**Brookvale Community Health Centre (SSD 6980)  
Notice of Exhibition**

TfNSW provides the following key comments on the above development application and the details of key comments are provided in **TAB A**.

## **TAB A – Detailed Comments on the Development Application**

Drawing
CARPARK LEVEL 1 FLOOR PLAN

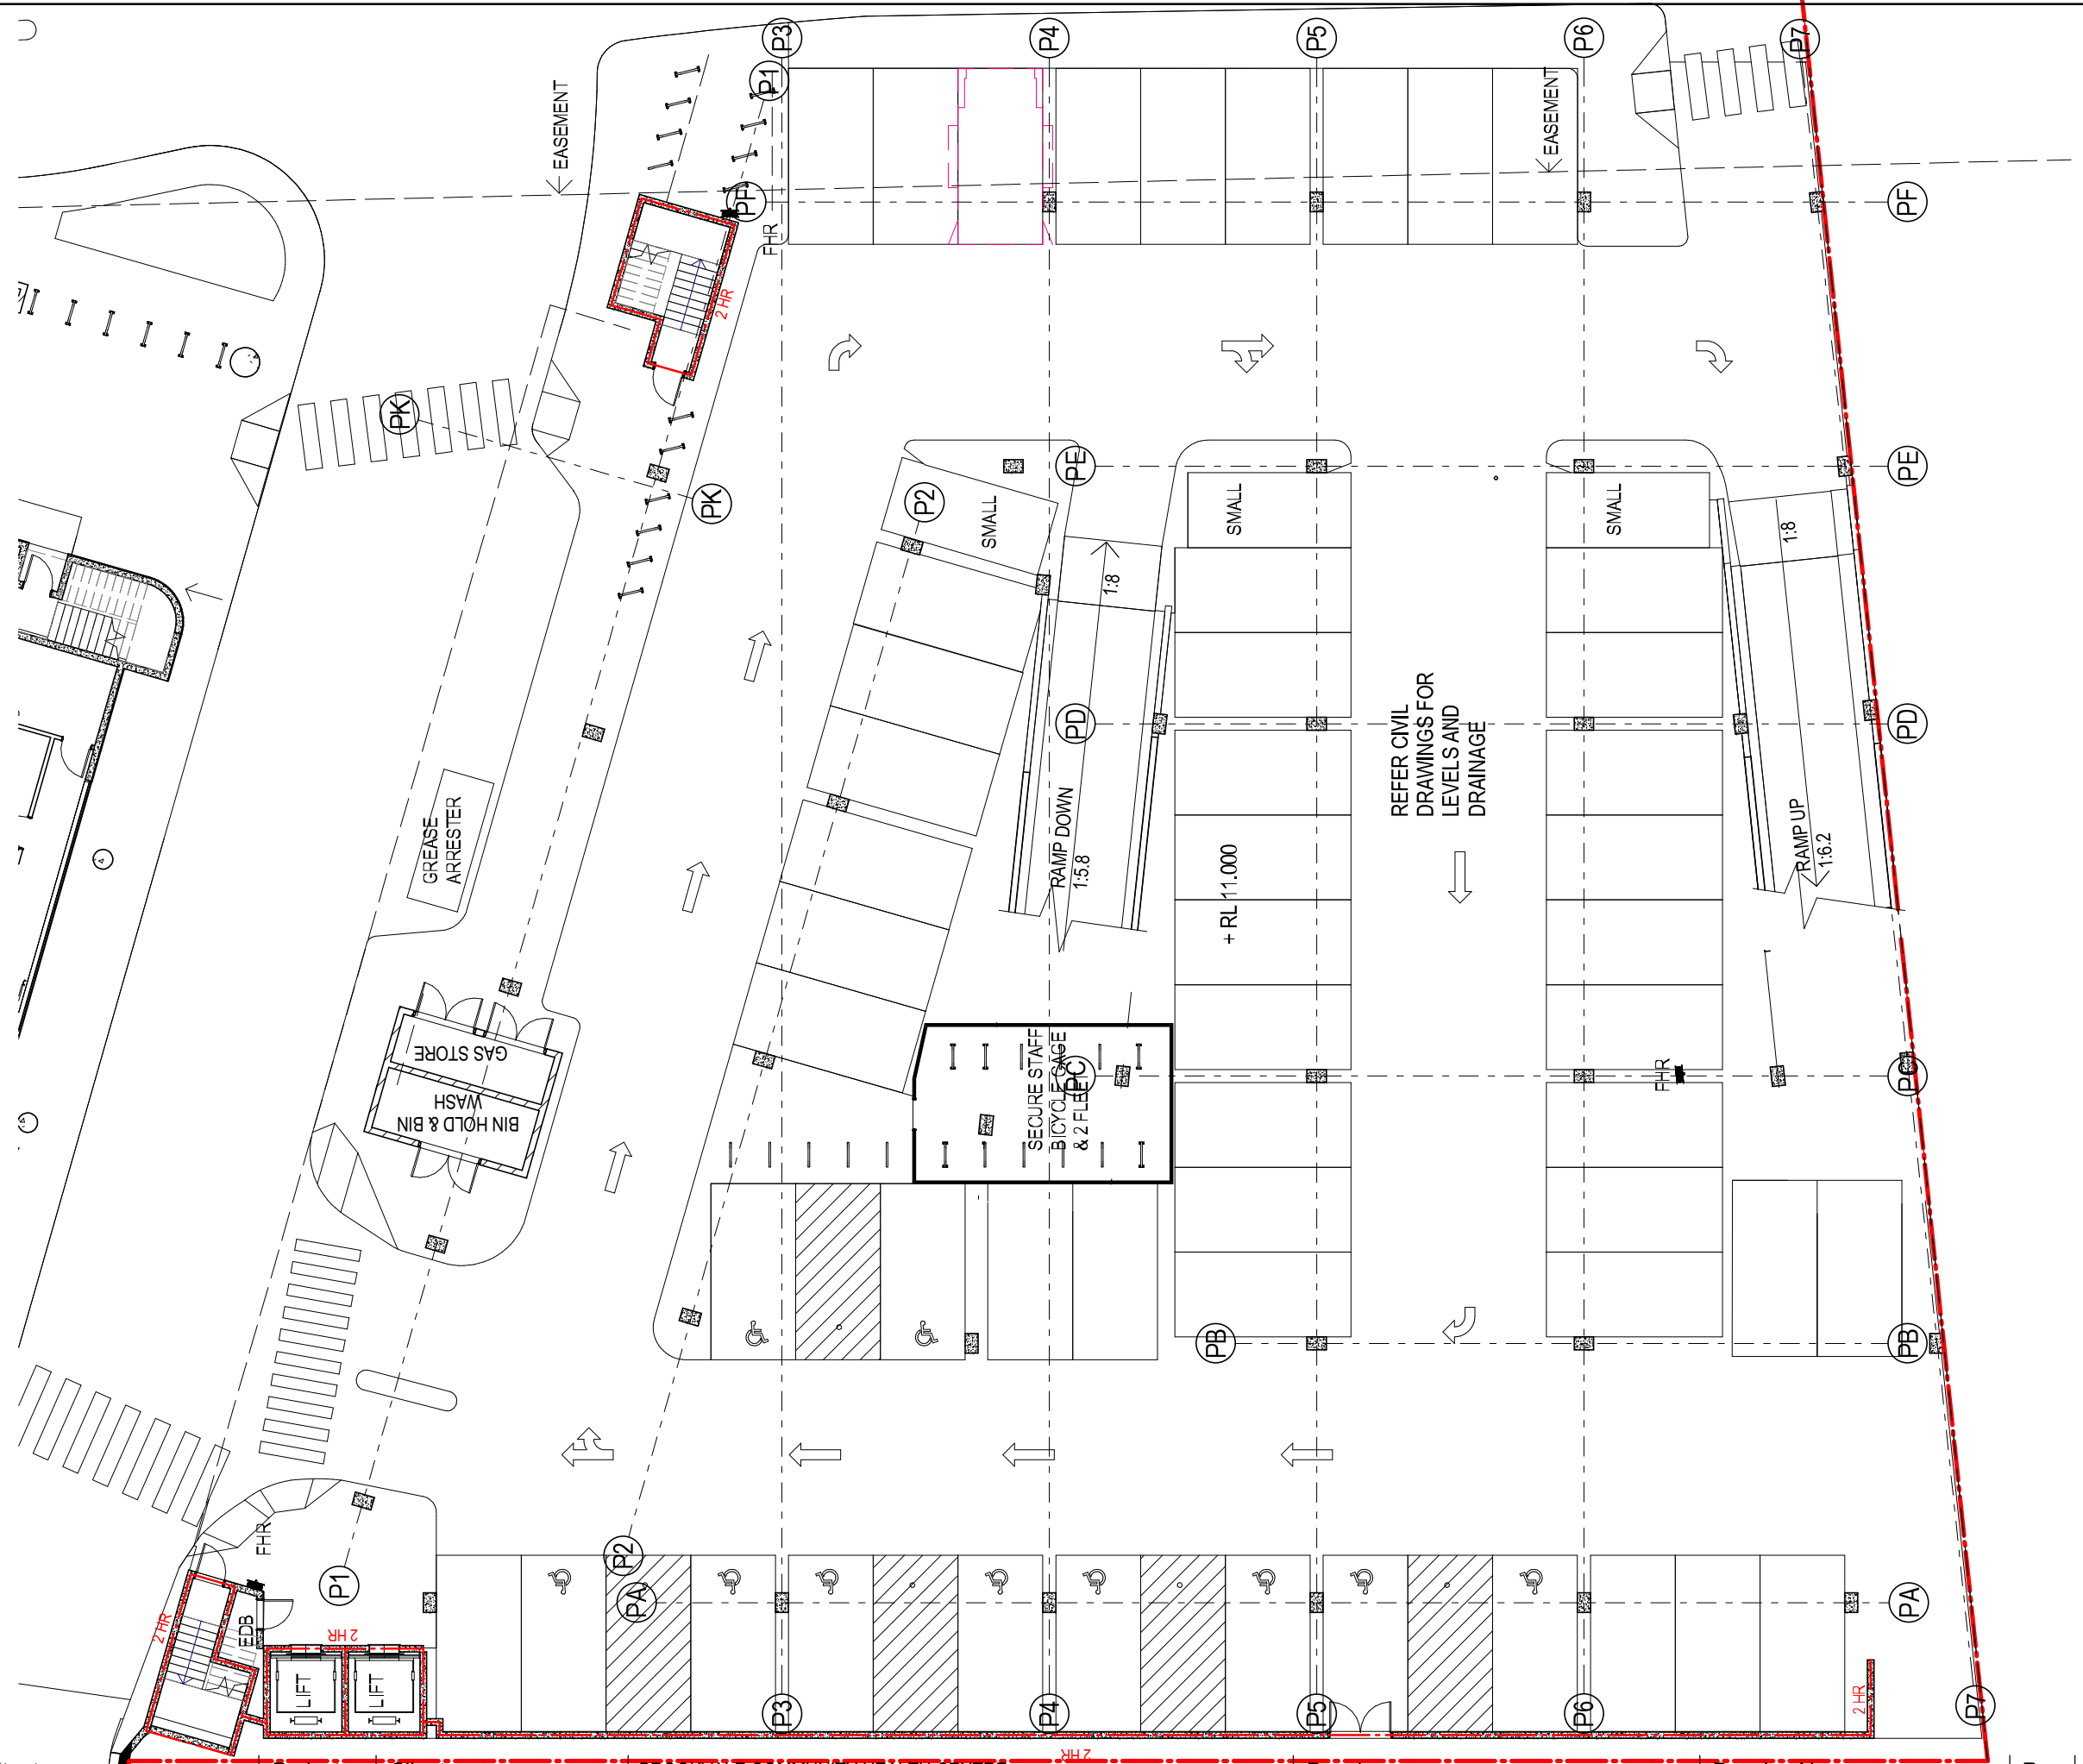
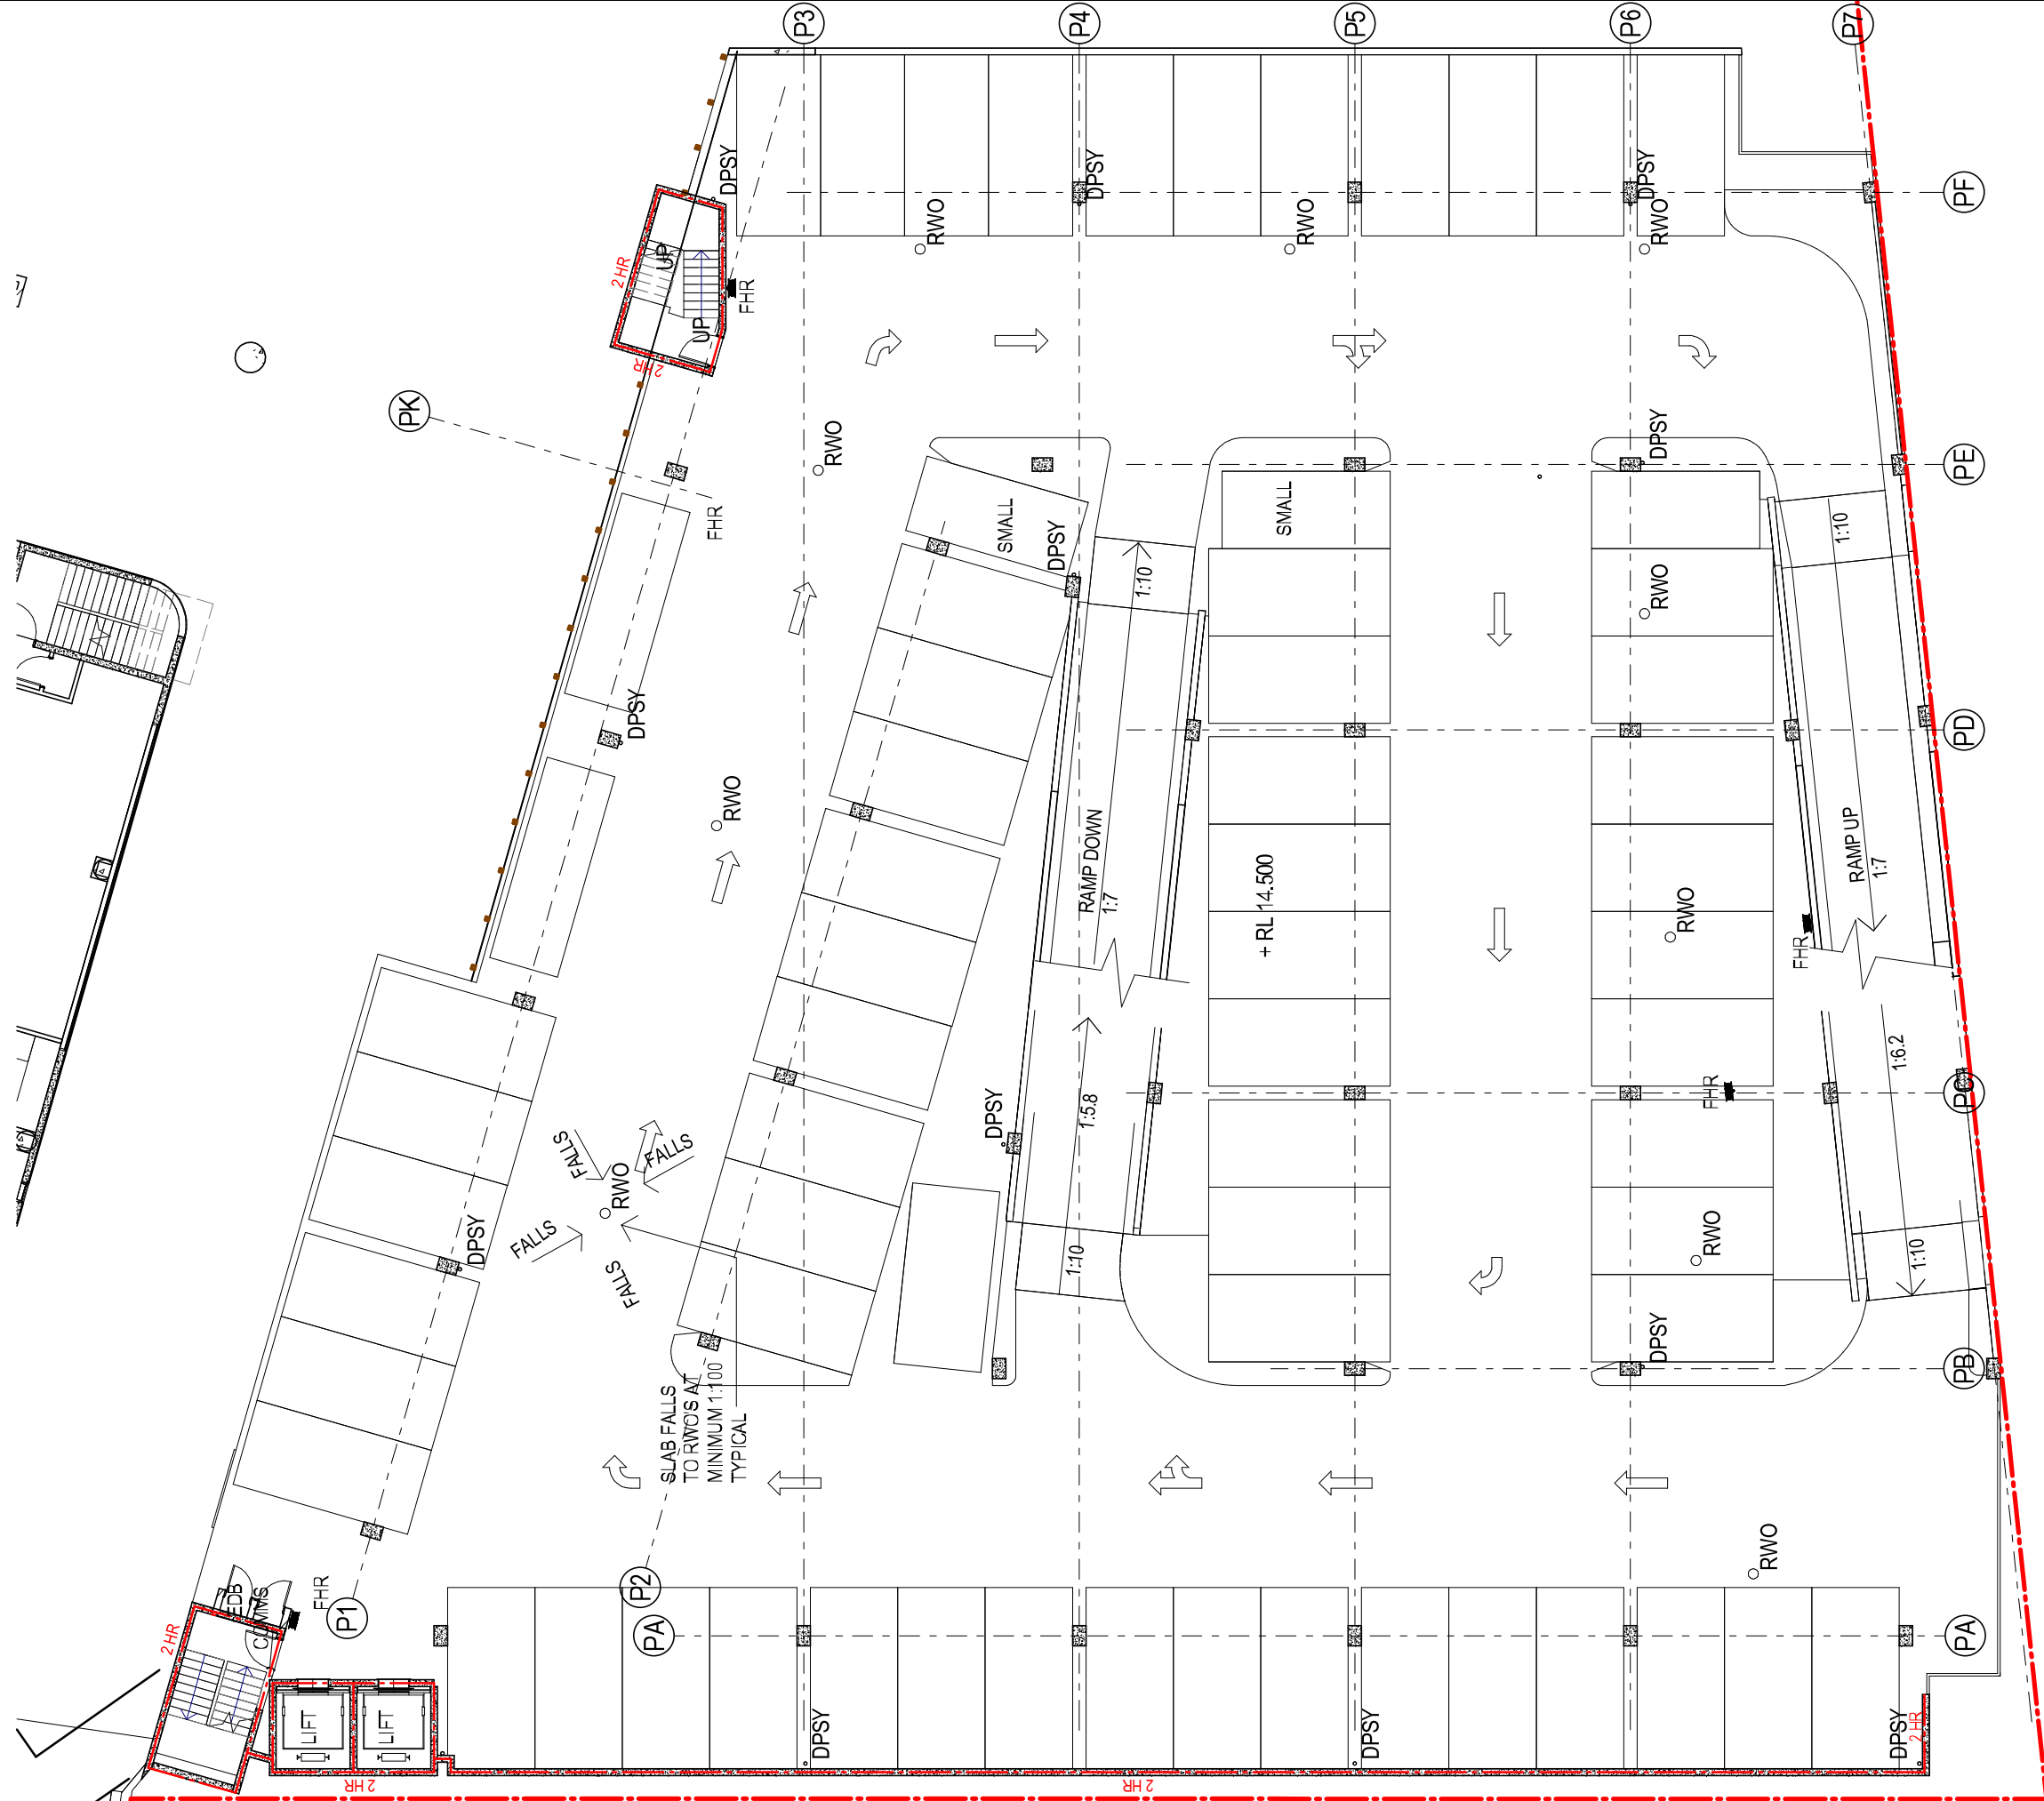
Any queuing from the BCHC access on Pittwater Road in the bus lane would have the potential to impact on travel time of bus services. It is likely that most of the commuter parking spaces would be fully occupied early in the morning. Vehicles looking for parking will enter the car park without the knowledge of unavailability of parking spaces. These unnecessary additional movements on the bus lane will cause disruptions to bus services.

TfNSW requests that the applicant consider and implement feasible measures to prevent the potential queuing of cars from the BCHC access on Pittwater Road into the bus lane. As an example, an electronic sign could be installed at the Pittwater Road car park entrance showing the real time information in relation to number of parking spaces that are free for short term parking and commuter parking.
